ITEM 1.1 (a)

Issue/ Objection:
Visual Privacy

85 Harrington Street
The Rocks
GOLDEN AGE & HANNAS THE ROCKS

TITLE
**RESPONSE TO DoPE
ITEM 1.1 (a)**

1 ELEVATION North Elevation Block 2
1:200

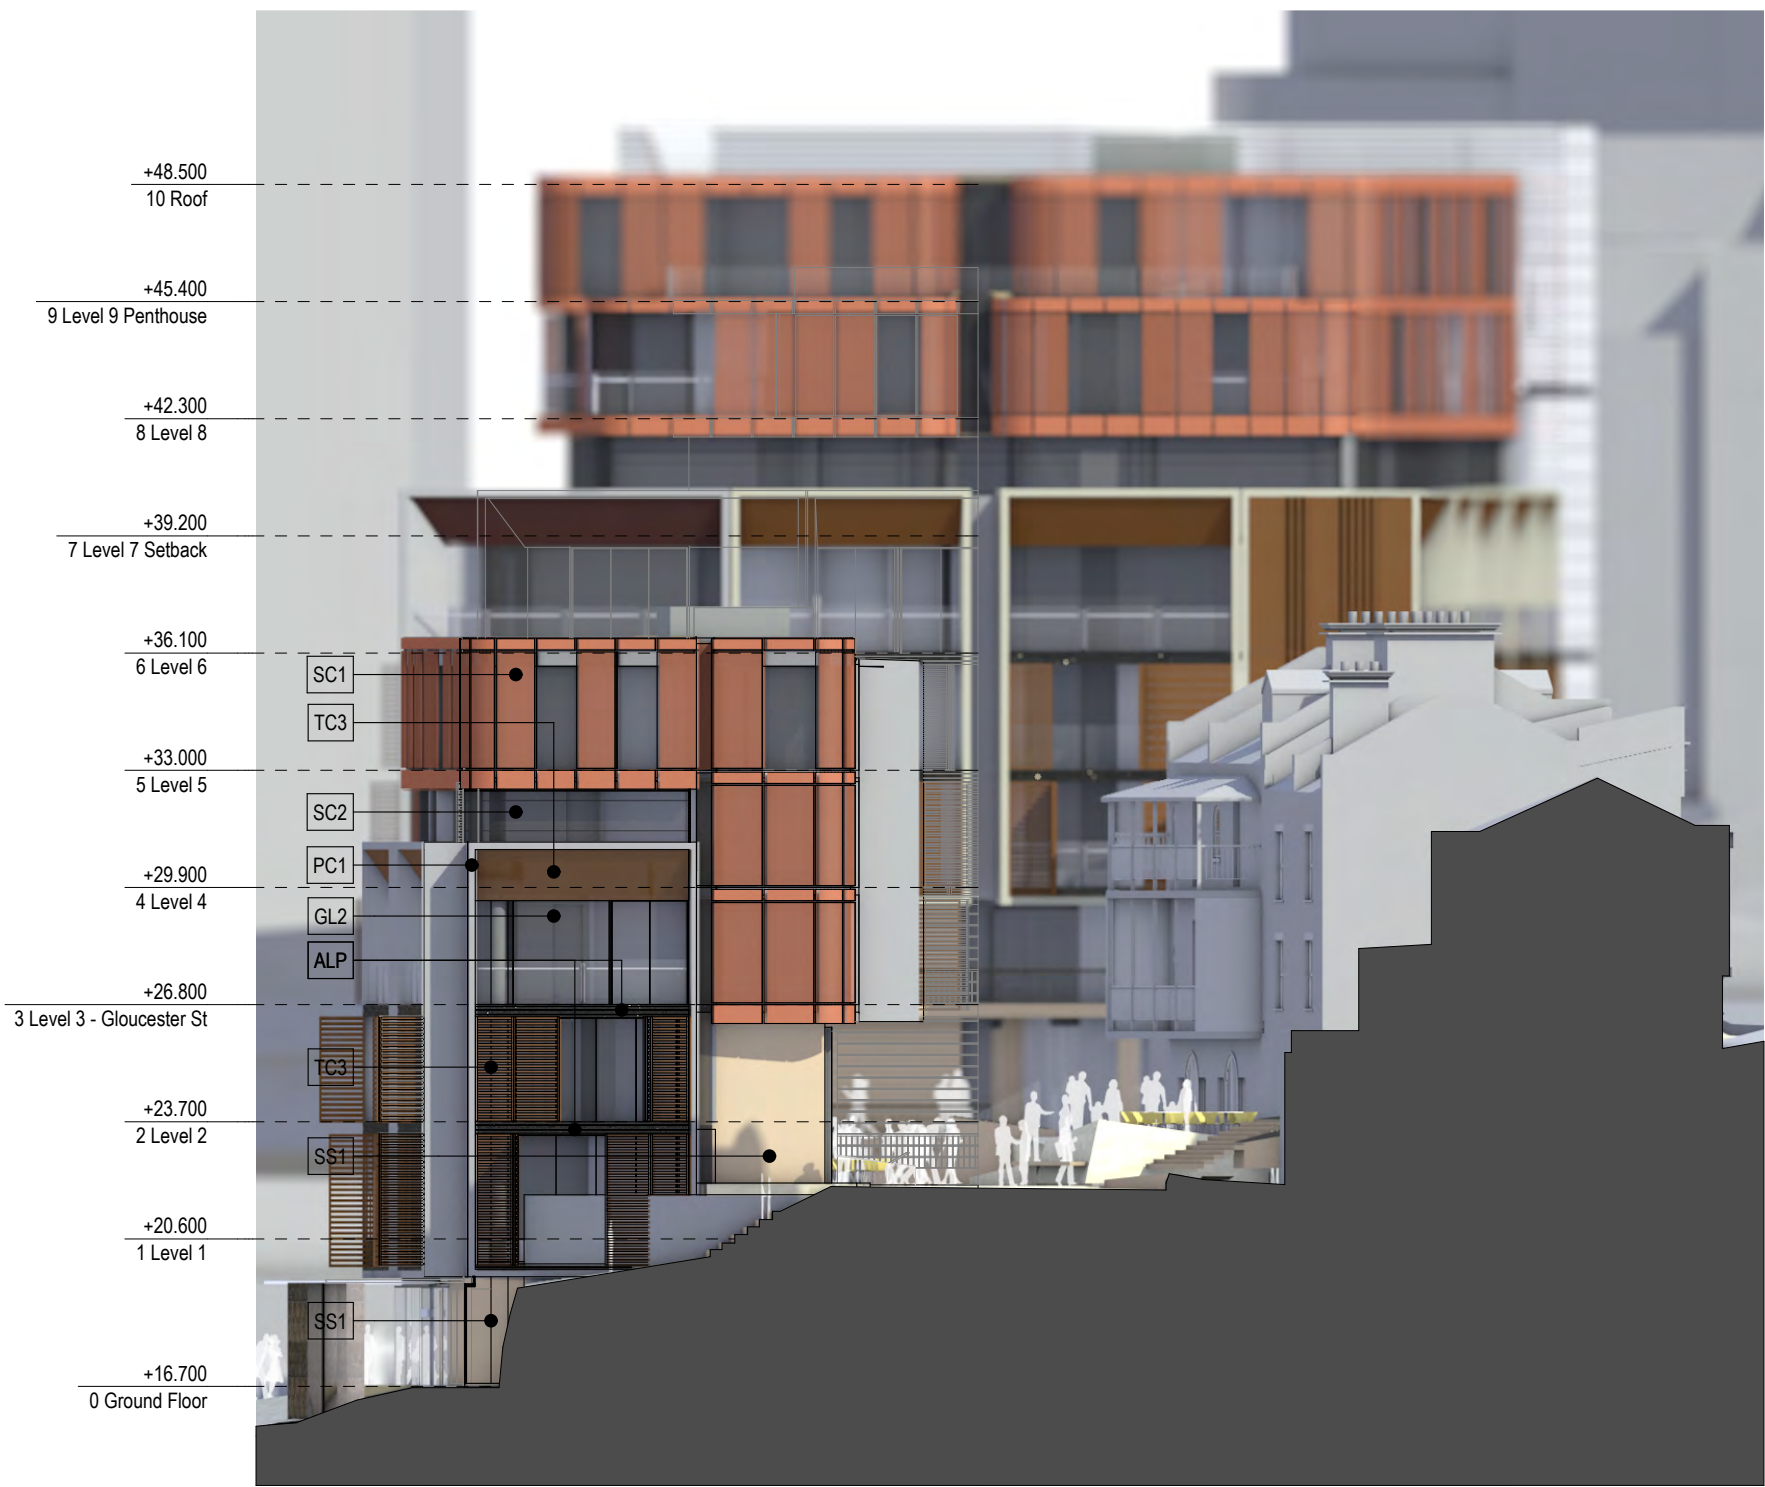
Description:
Description: Balconies serving units on Northern side of Building 2 have been reorientated towards Rendezvous Hotel. Provide a specific plan illustrating the varying setbacks between the two buildings, location of facing windows and balconies and proposed design measures to mitigate potential privacy impacts.

Response
Solid, operable shutters, or horizontal metallic blinds that are controlled by the occupants of the unit are employed to provide privacy towards the subject site. The windows of question within the rendezvous hotel are fixed, have dark glass and the rooms are itinerantly occupied. Any potential privacy issues have been mitigated through a considered design response. **Complies? Yes**
